Objection to WA/93/20/PL

I object to the application WA/93/20/PL on several grounds.

AVISFORD PARK ROAD

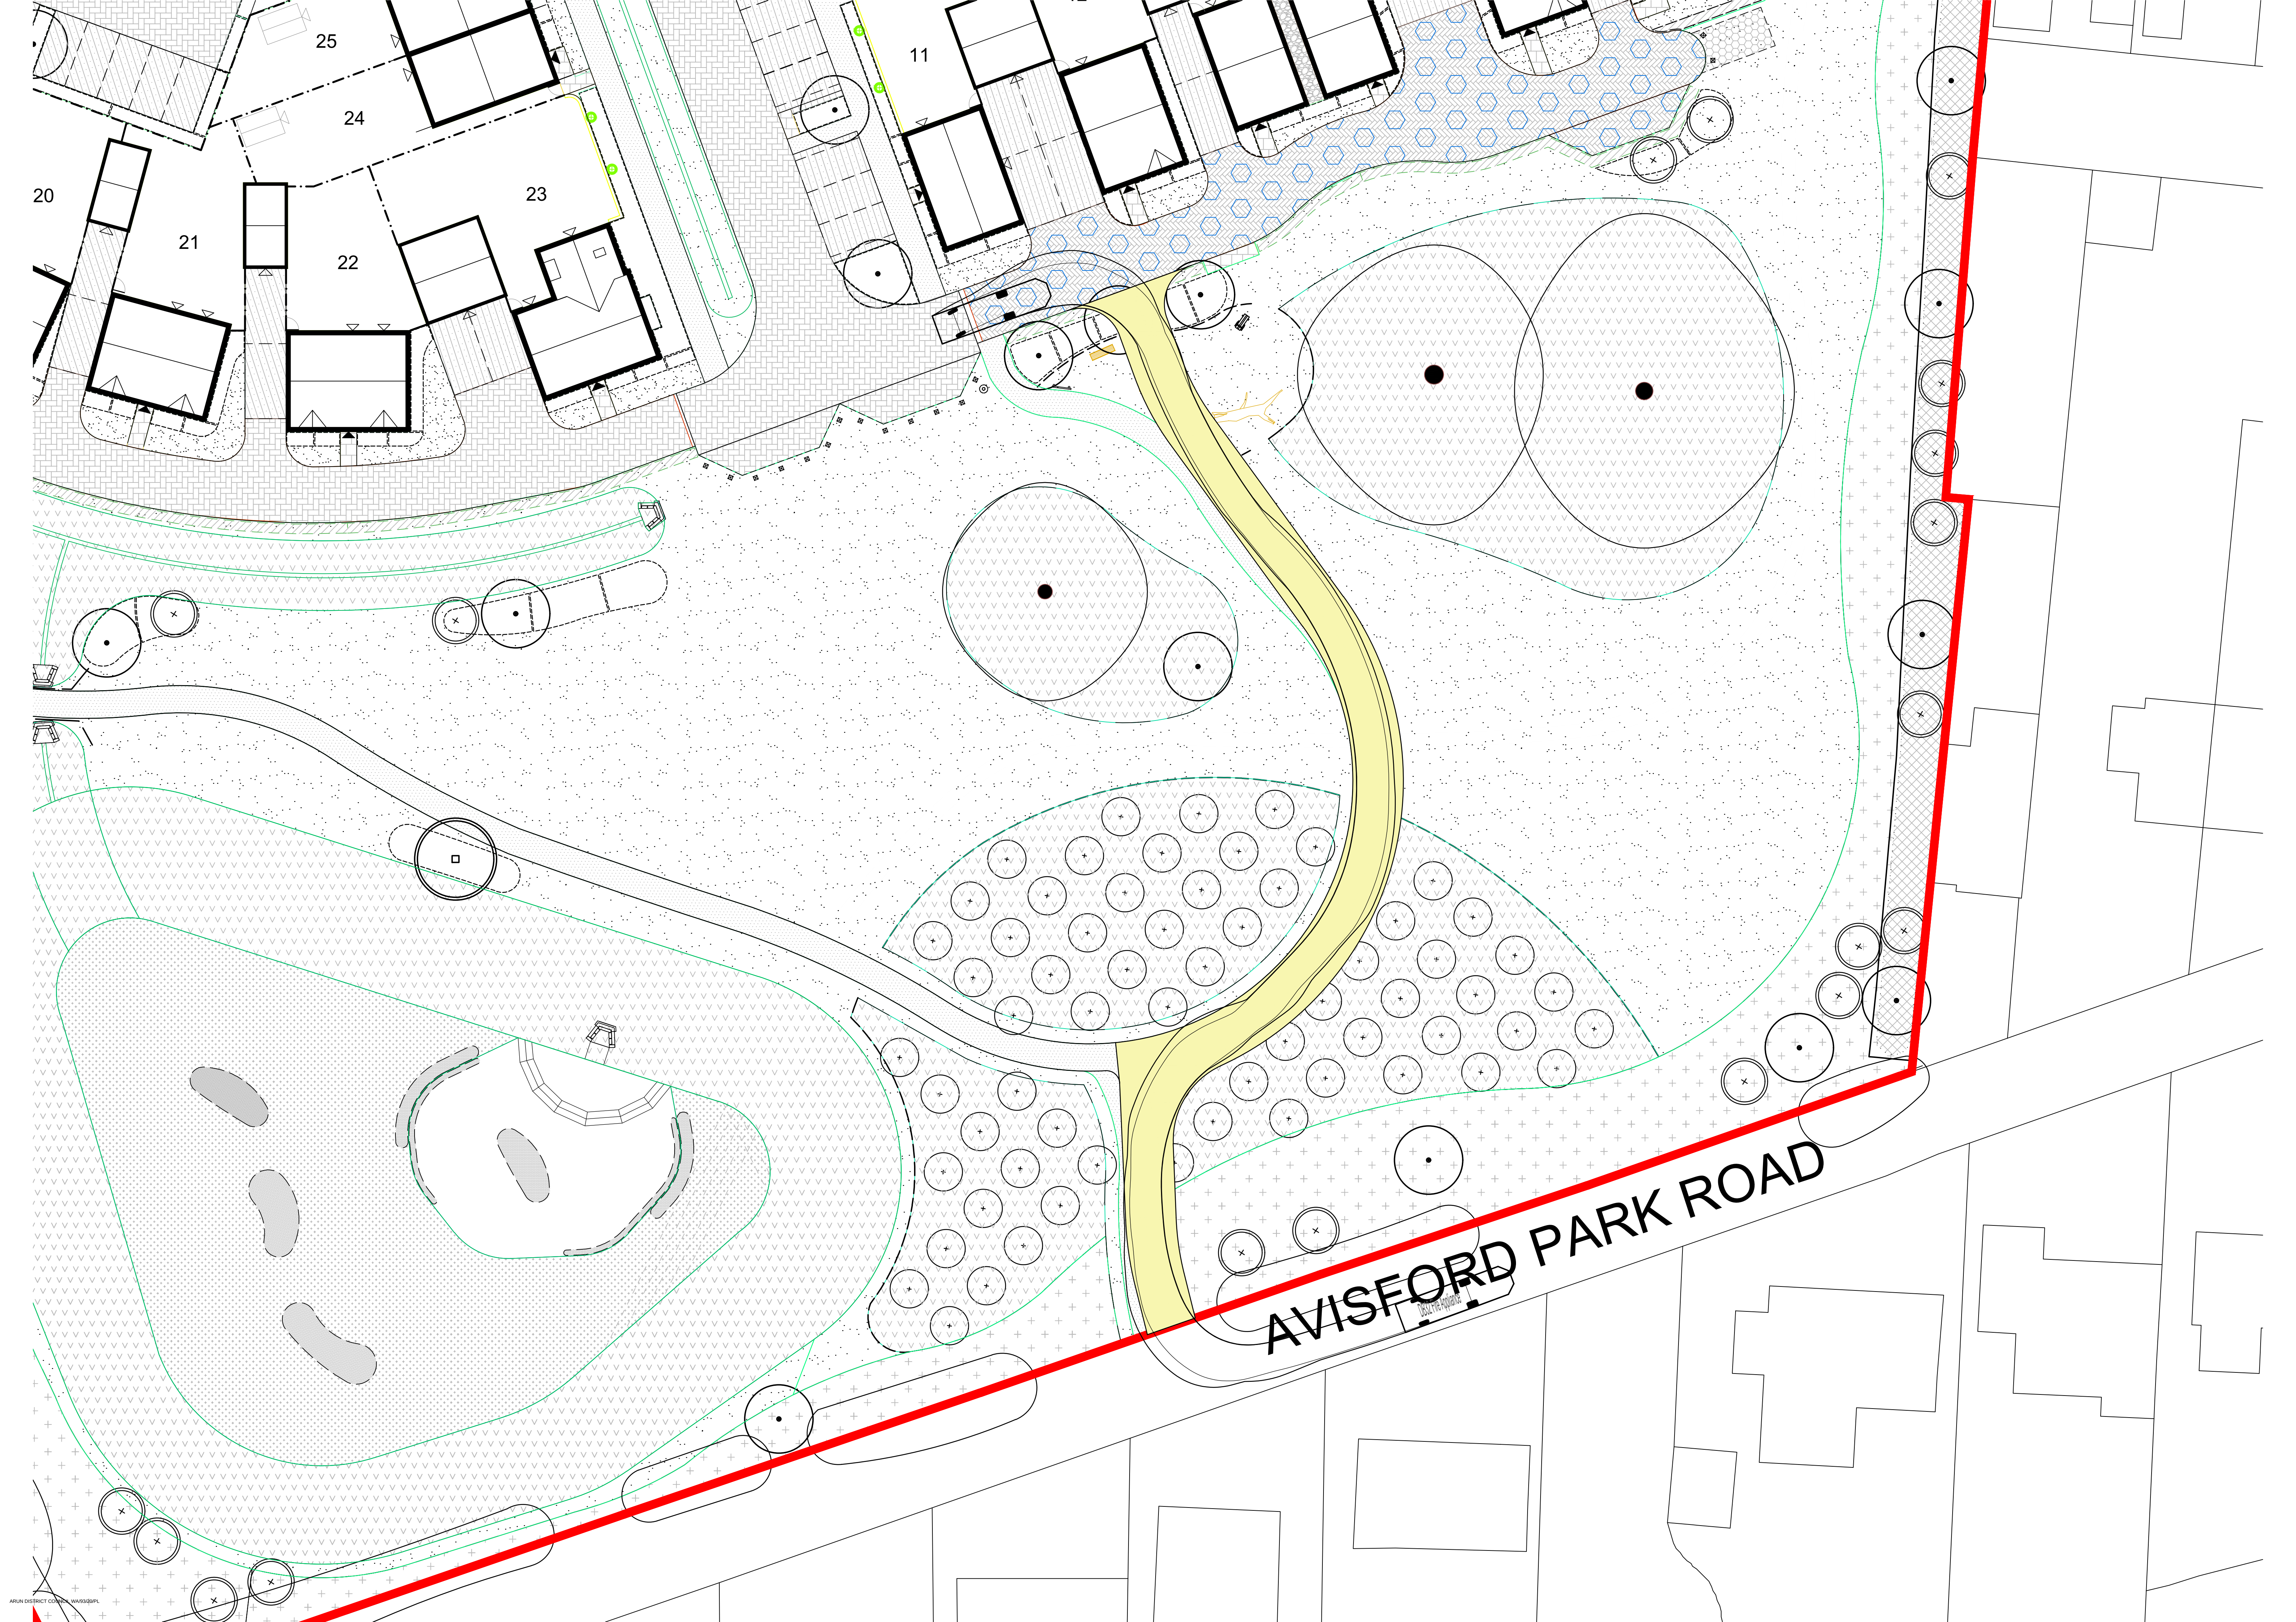
The plans provided are very scarce in detail in particular how the proposed emergency exit access on Avisford Park Road will impact on the plans for the development. The agreed reserved plans (WA/95/18/RES) are for an orchard where the access is proposed but there are no detailed plans to see how this will be impacted and no analysis about how it could affect the drainage on site.

There is also very little detail on the emergency gate on Avisford Park Road access. Would this be in place? Will it be locked? If not then it could become a rat run into and exiting the development and

that would lead to major traffic and safety issues along the road itself and onto Yapton Lane. The road is not fit for this level of use, it is a potholed (in places, single vehicle) track and as a resident on this road with a financial responsibility for its upkeep how would I and other residents be recompensed for the potential access? Additionally, as it is a single lane track at points, this leads to regular blocking when larger vehicles are delivering etc. This should be taken into account as it is not a suitable position for an access to emergency vehicles.
